May 7, 2008

**Re: Status of Improvement Permit Application #08-5-19917  
Shawn & Stacey McCracken**

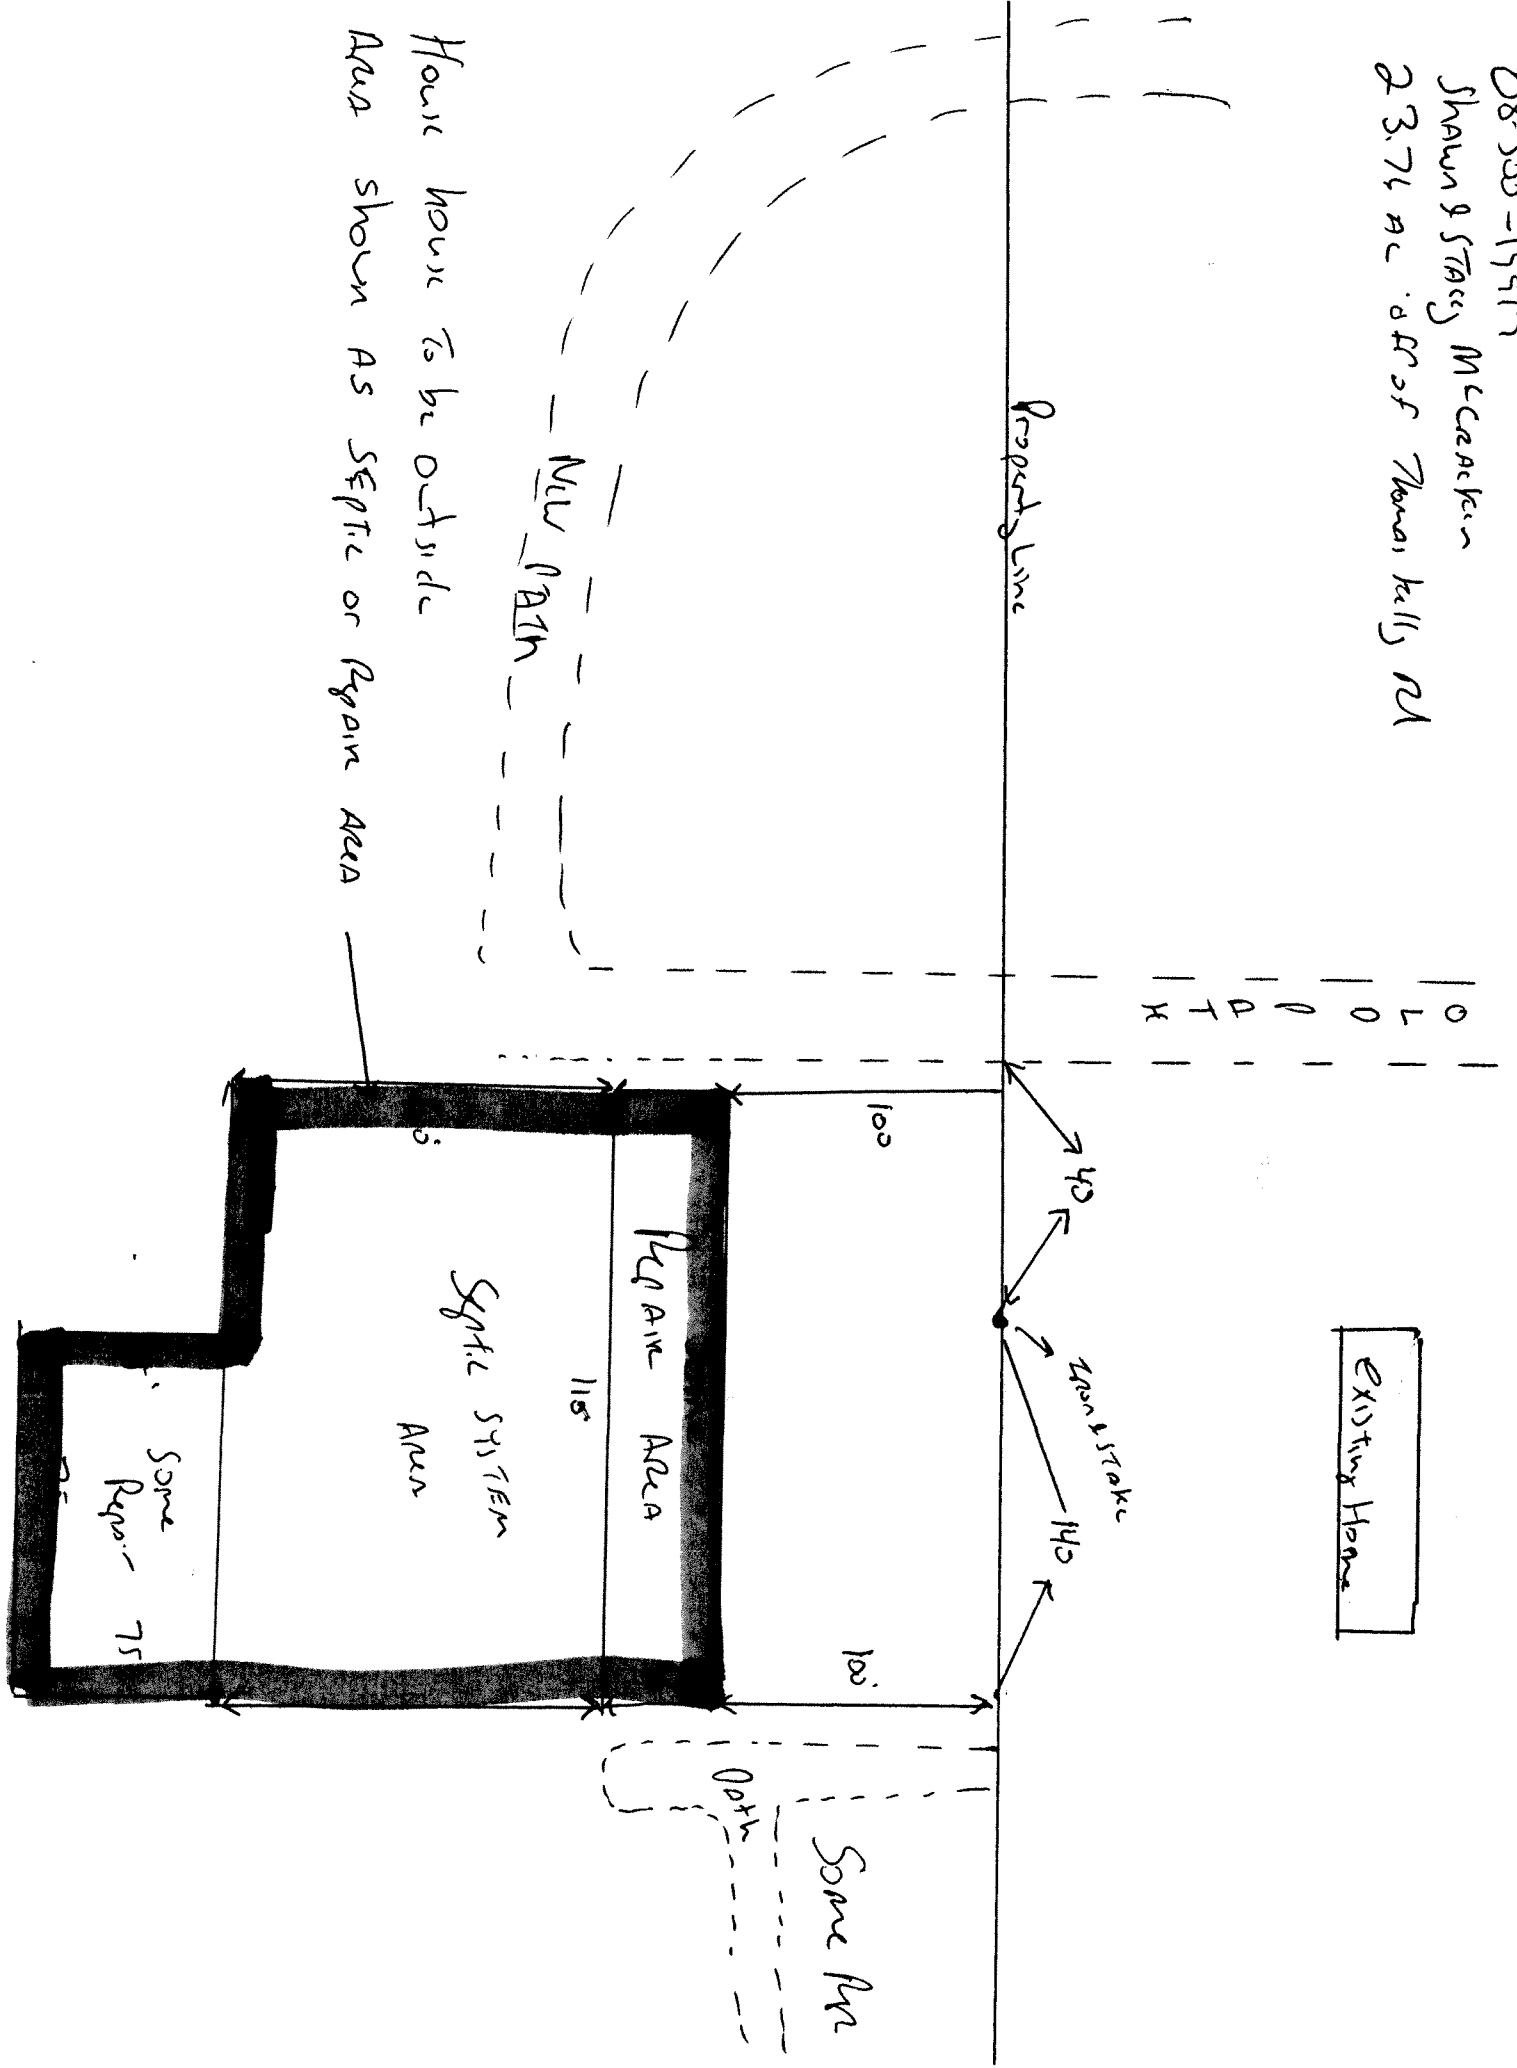
- 1. Property lines/corners not marked or labeled
- 2. House corners not marked or labeled
- 3. Directions not clear to property
- 4. Property needs brush or vegetation removed
- 5. Backhoe pits required
- 6. **Other – The area where you placed the home site is where the private consultant has designated as suitable soils for septic system. You can either move home out of that area or have backhoe pits dug. (Rocky soil conditions)**
